DOC22/110043-4

Orica Southlands Warehouse Estate SSD 9691 Mod 1

I refer to the Department of Planning and Environment's request for advice in relation to Orica Southlands Warehouse Estate SSD 9691 Mod 1. In responding to the Department's request the NSW Environment Protection Authority (EPA) has reviewed the *Modification Report* (Keylan Consulting Pty Ltd, 21 December 2021) (the Report).

DRIVEN PILES - OVERALL PILE PLAN
1 : 300

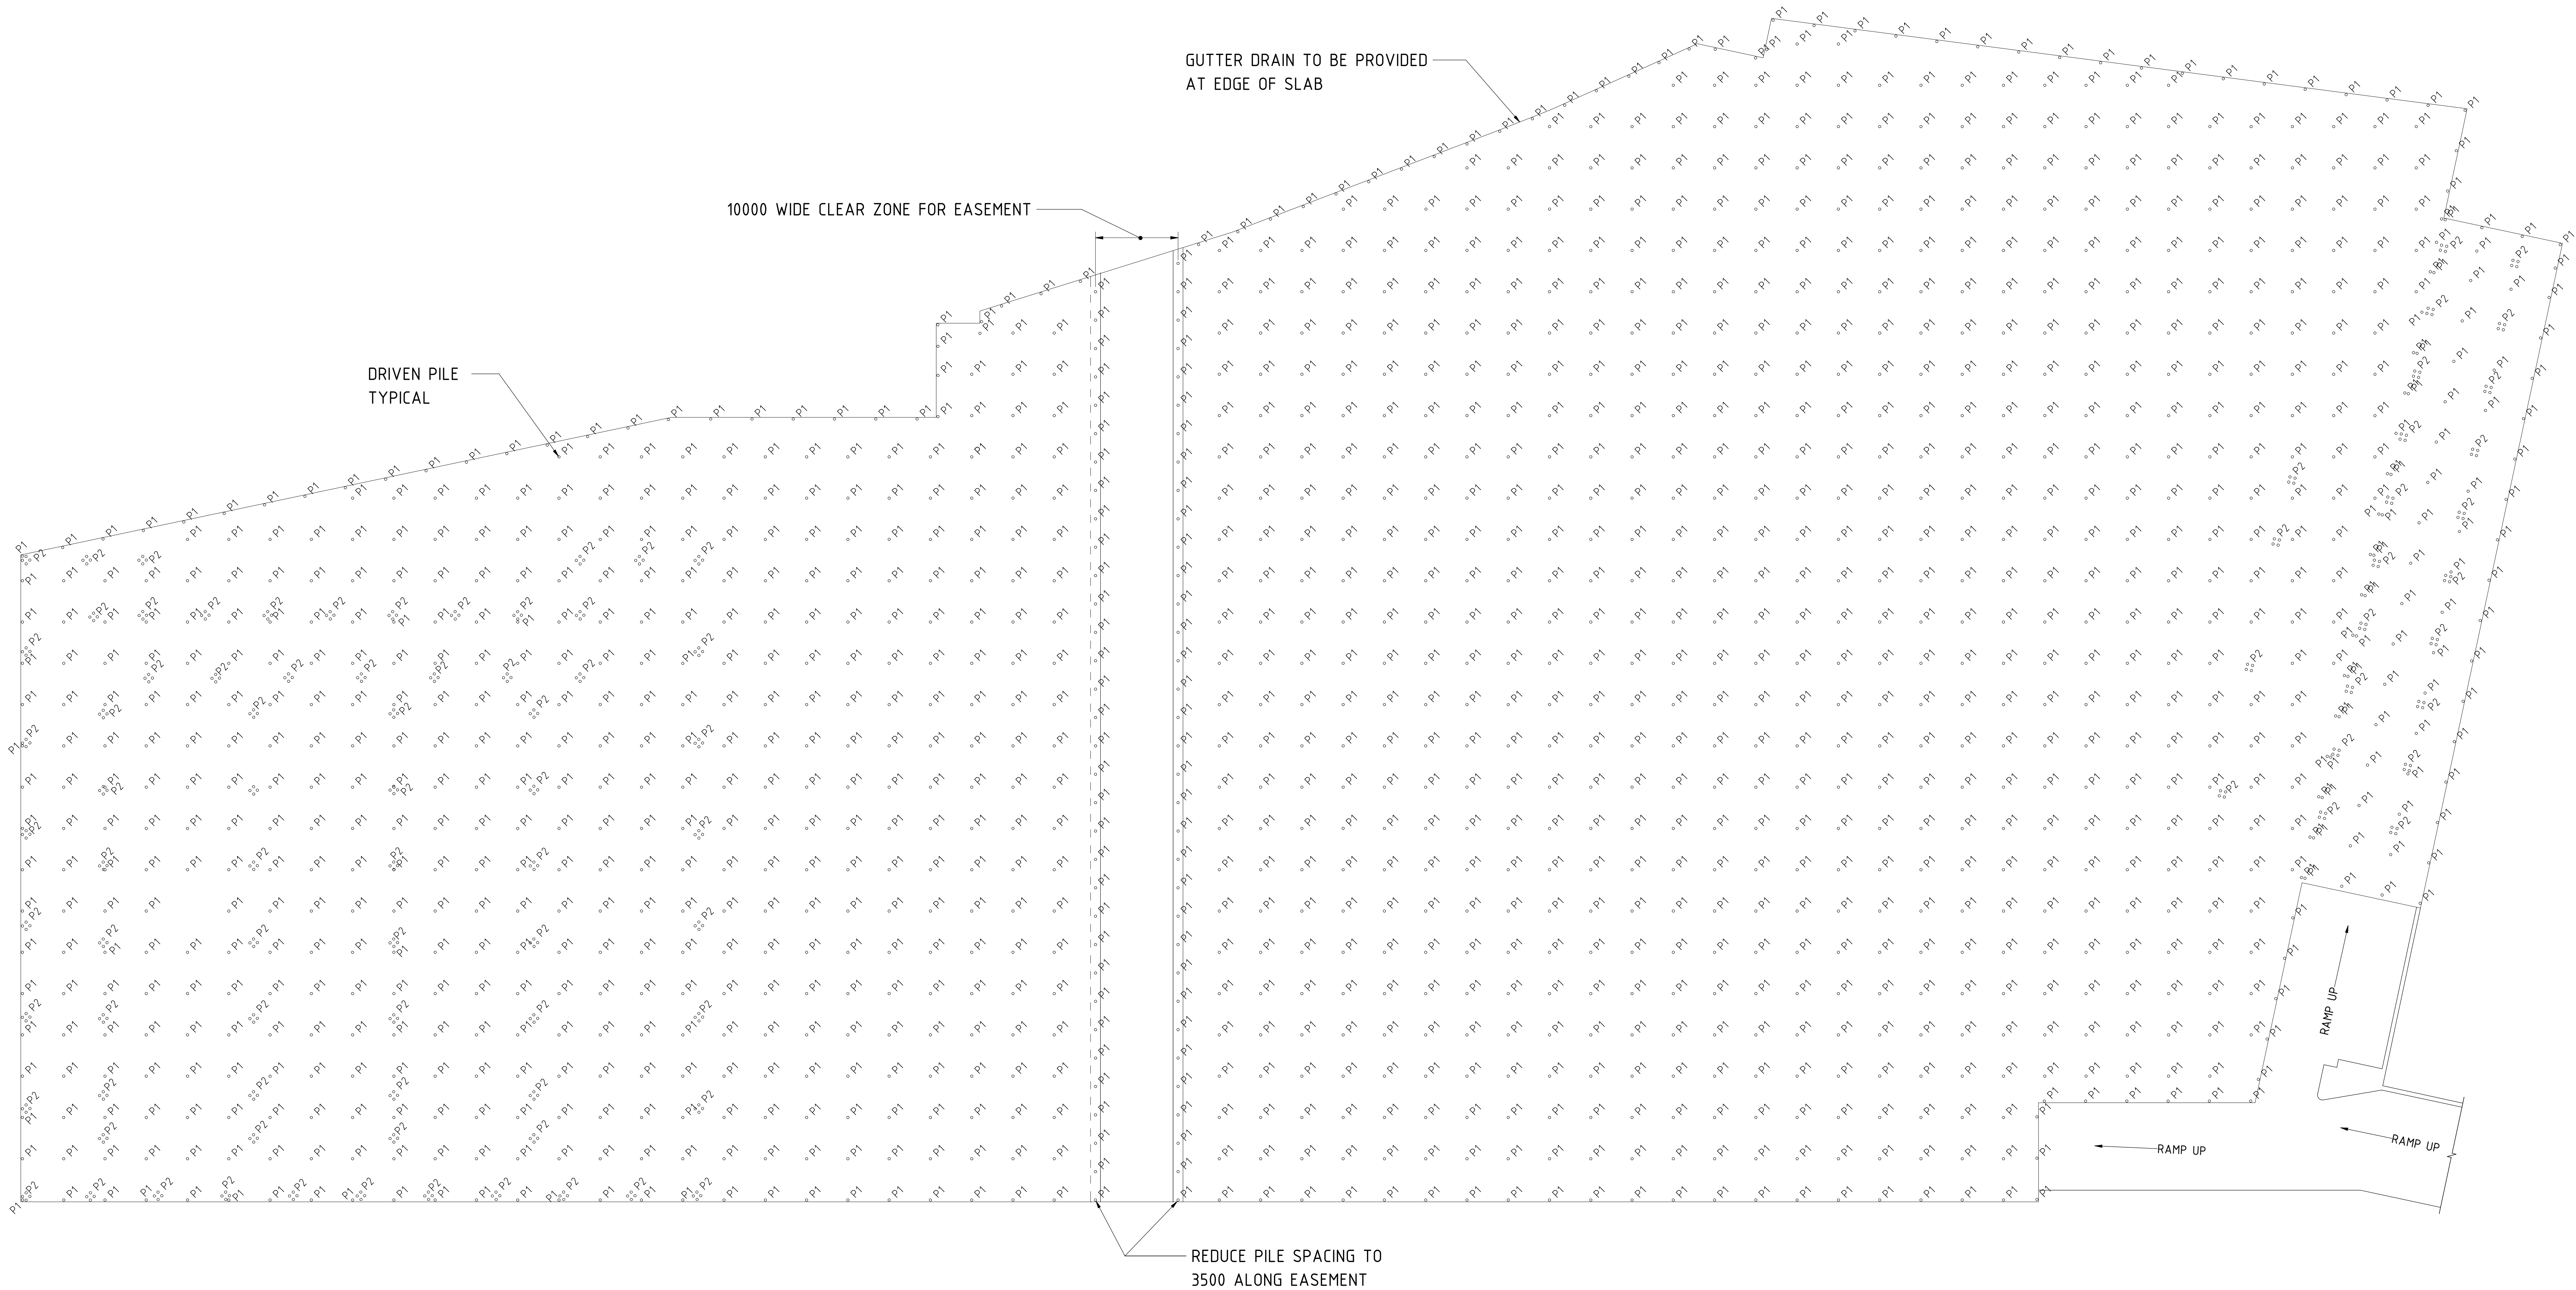
- *changing the intervals of the supporting piles from 10m to generally 5m with additional piles to support structures on top of the elevated platform*
- *reducing the size of each individual piles from 800mm to 400mm in diameter*
- *no longer including footings for the piles*

While the Report includes the general statement that *the spacing of the piles is designed to ensure that access for maintenance vehicles under the platform is maintained*, the EPA is primarily concerned with Orica being able to undertake intrusive remedial works beneath the elevated platform should such works be required. This is anticipated to require the use of a drill rig.

Prior to commenting on the appropriateness of the proposed modification, the EPA requires further information either from the Applicant and/or Orica, as the party responsible for the ongoing management of the underlying contamination, to demonstrate that the proposed changes to the supporting pile structure will not impede such works.

Figure 3: Site piles plan (Source: Costin Roe)

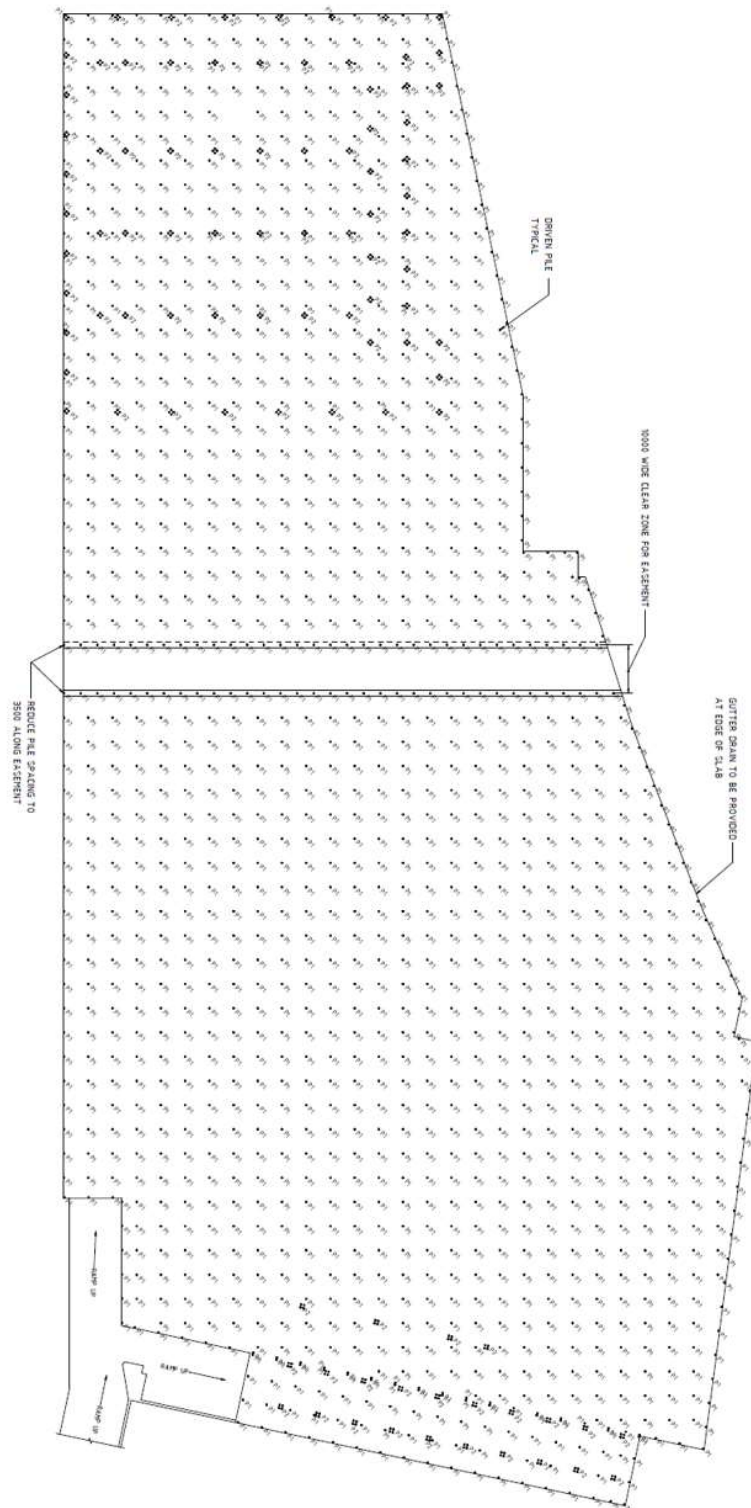
The Report states that the proposed modification in relation to the elevated concrete platform includes:
